PROJECT NO. 1002126	APPLICATION NO. 02DRB-01872
PROJECT NAME FRIEDMAN SUBD (LOTS A B C)	
EPC APPLICATION NO.	
APPLICANT / AGENT ROSS HOWARD	PHONE NO. 897-0291
ZONE ATLAS PAGE F-17	
ONE STOP COMMENT FORM LOG

DEVELOPMENT REVIEW BOARD--SPEED MEMO

DRB CASE NO/PROJECT NO: 1002126

DEVELOPMENT REVIEW BOARD TRANSPORTATION DEVELOPMENT Standard Comment Sheet

DATE: 5-1-02	DRAWN BY: J.H.
SHEET: 2 OF 2	CHECKED BY: R.H. JOB NO. 5050
REVISIONS:	REVISIONS:
REVISIONS:	REVISIONS:

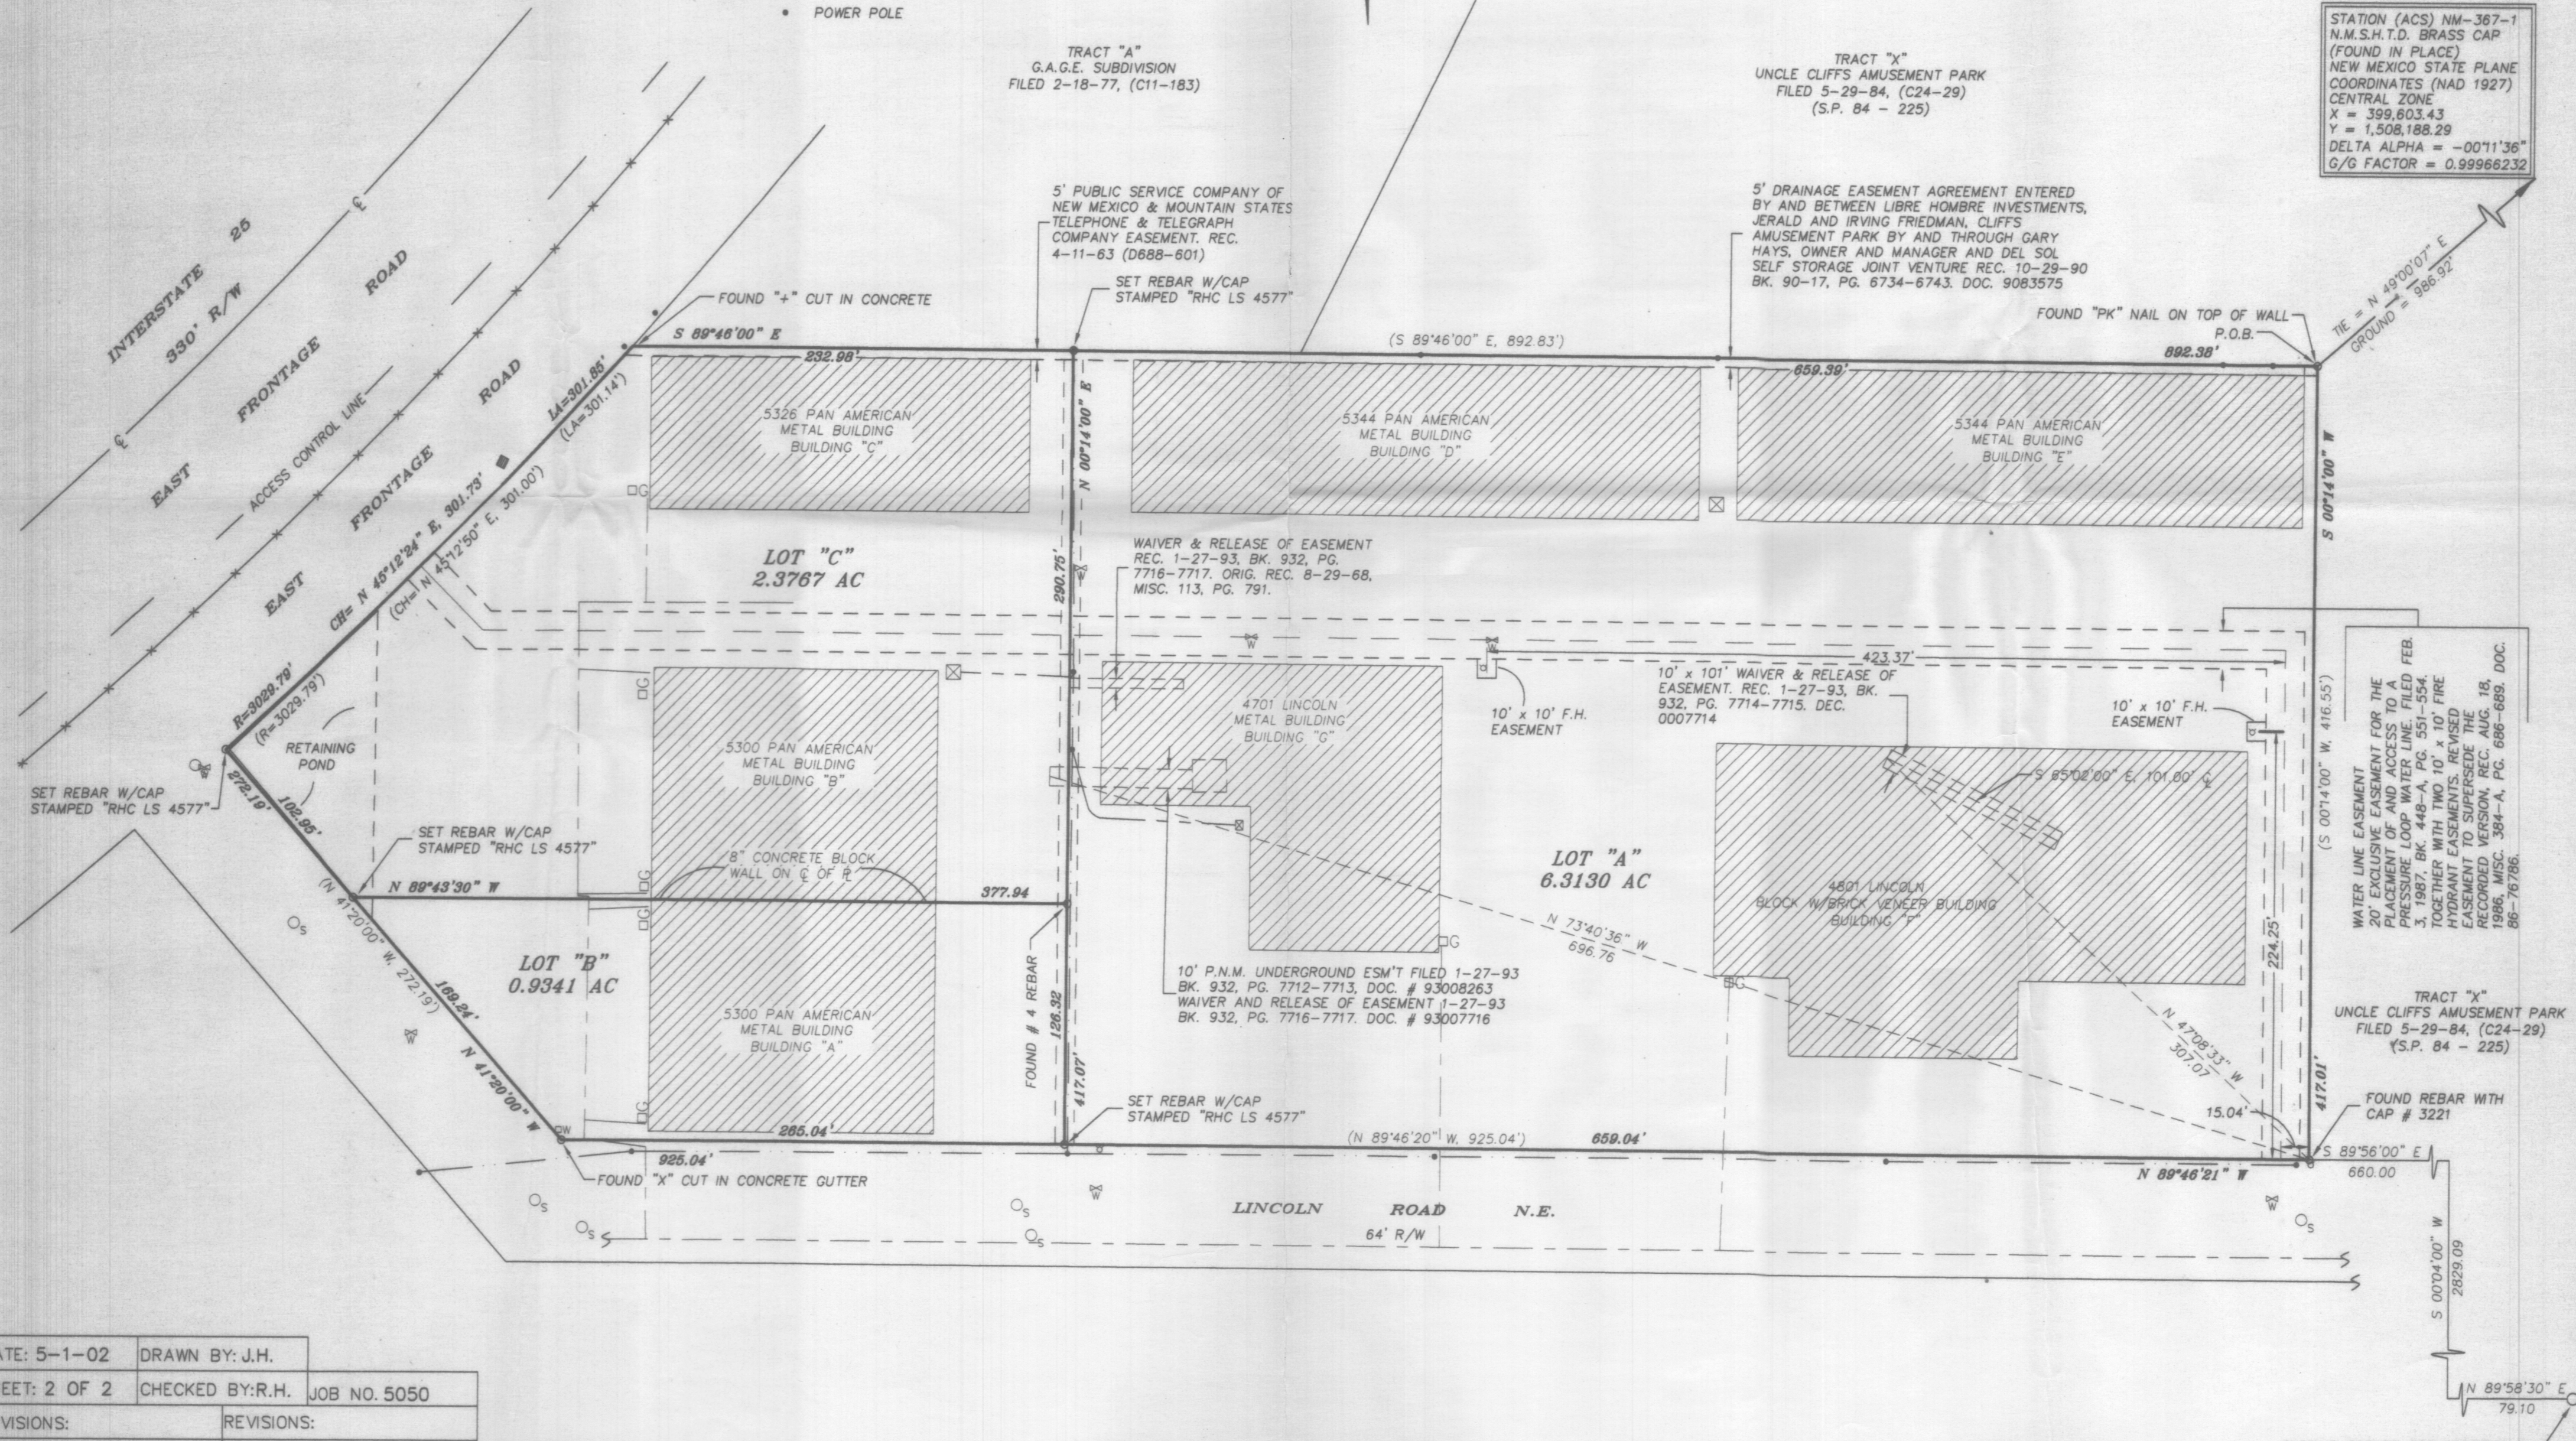
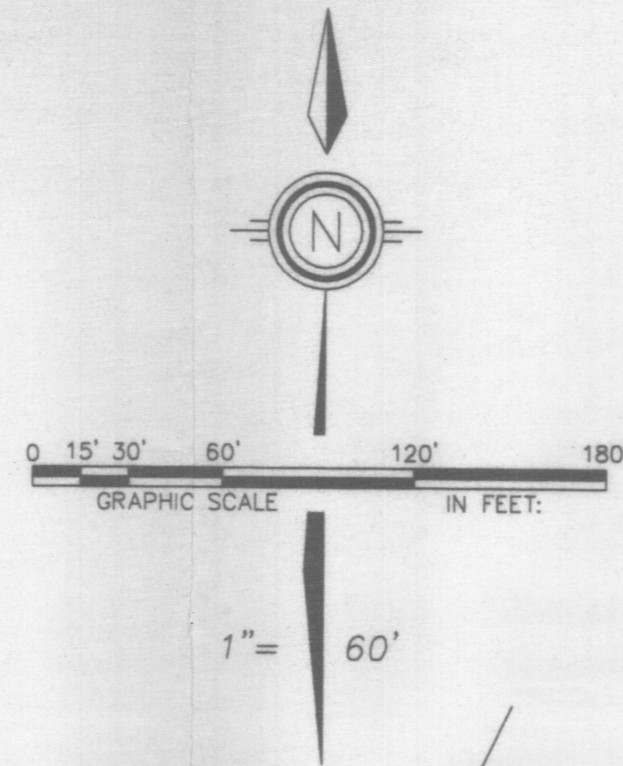
TRANSPORTATION DEV (505) 924-3990		
PLANS DISAPPROVED <i>RV</i>	DATE 12-12-02	DATE
PLANS APPROVED <i>RV</i>	DATE 12-24-02	DATE
COMMENTS:		
Easement #2 should connect to Lot "B."

Cross-lot drainage easements, private drainage covenant required.
 Show floodplain on plat.

No.	Comment
<input type="checkbox"/>	How is access to be provided? Easements appear to be needed.
